# **RODERIC O'GORMAN TD DUBLIN WEST**

**Minister for Children, Equality, Disability, Integration and Youth**

**Re: Busconnects Blanchardstown to City Centre CBC Scheme – Statutory Consultation**

Programme Title: BUSCONNECTS DUBLIN			
Drawing Title: CORE BUS CORRIDORS INFRASTRUCTURE WORKS			
Drawing File Name: BCIDC-ARP-GEO_GA-0005_XX_00-DR-CR-0001			
Sheet Number: 01 of 40	Status: A	Rev: M01

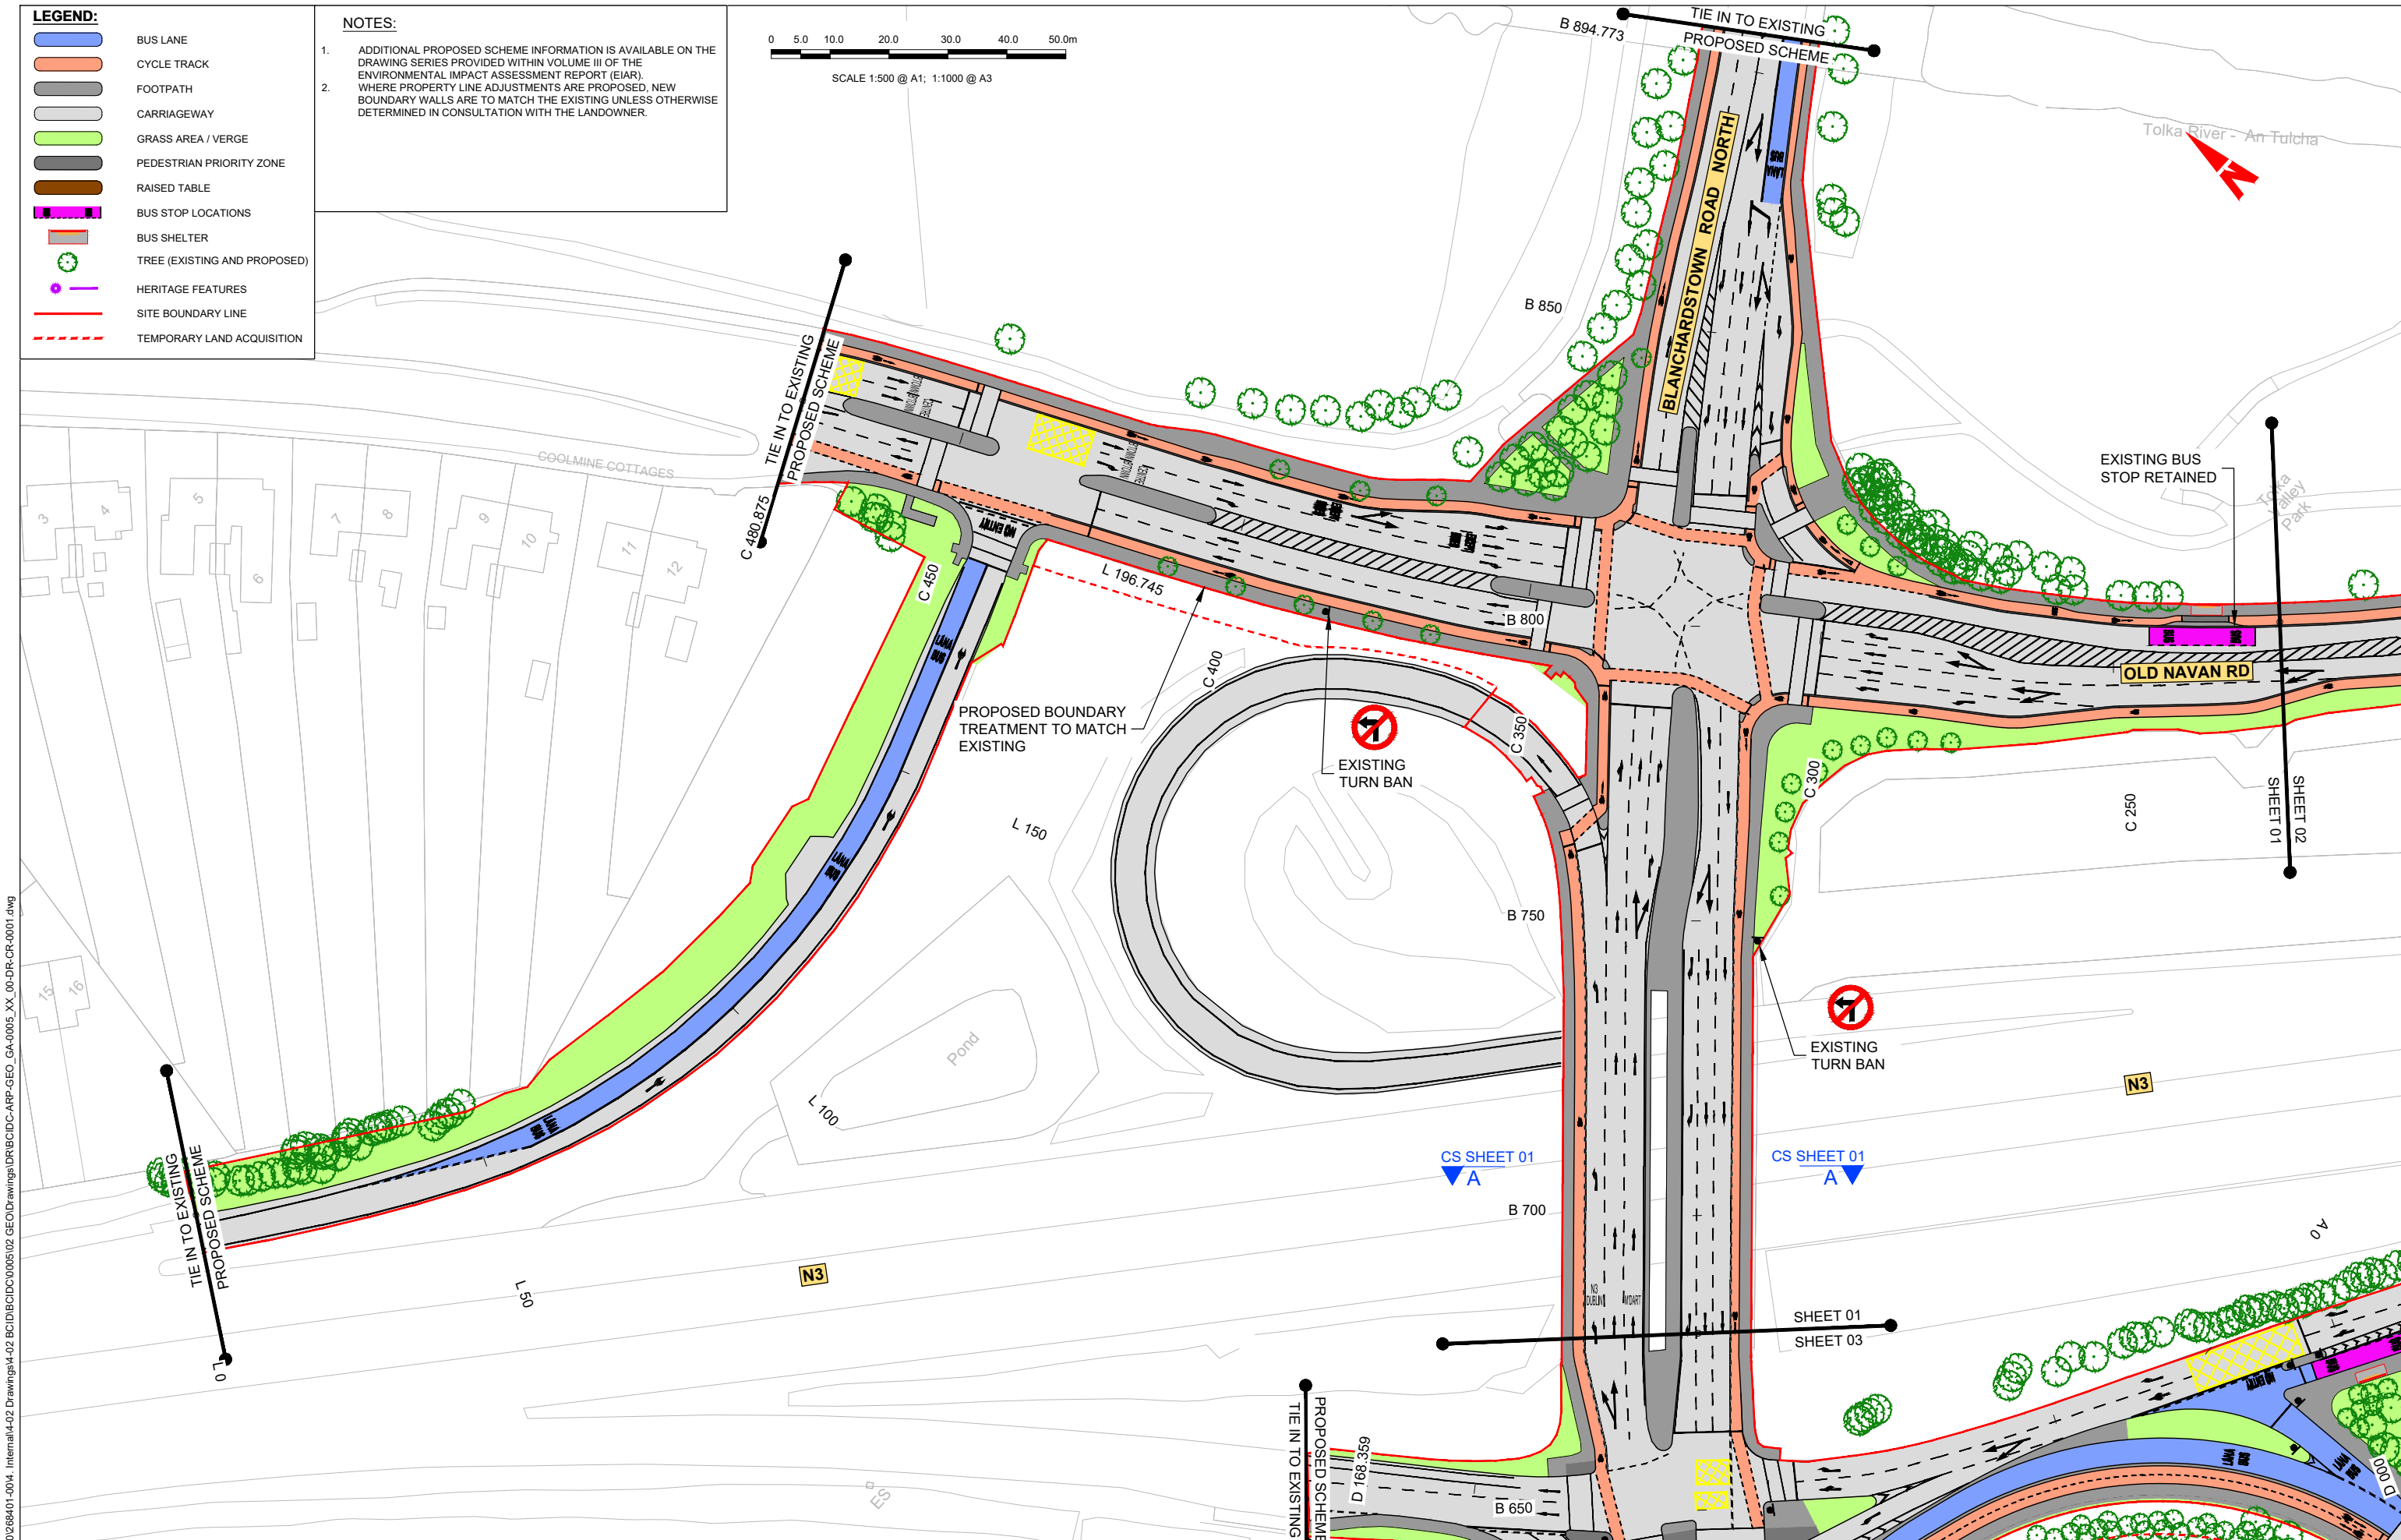
For example, sheet 1 of the Blanchardstown to City Centre Core Bus Corridor Scheme General Arrangement shows a slip lane turning left from the Blanchardstown Road North onto the Old Navan Road. A pedestrian crossing Blanchardstown Road North at this location must do so in three phases. Removing the slip lane would mean that a pedestrian would cross the road in two phases, as well as slowing traffic down at this location.
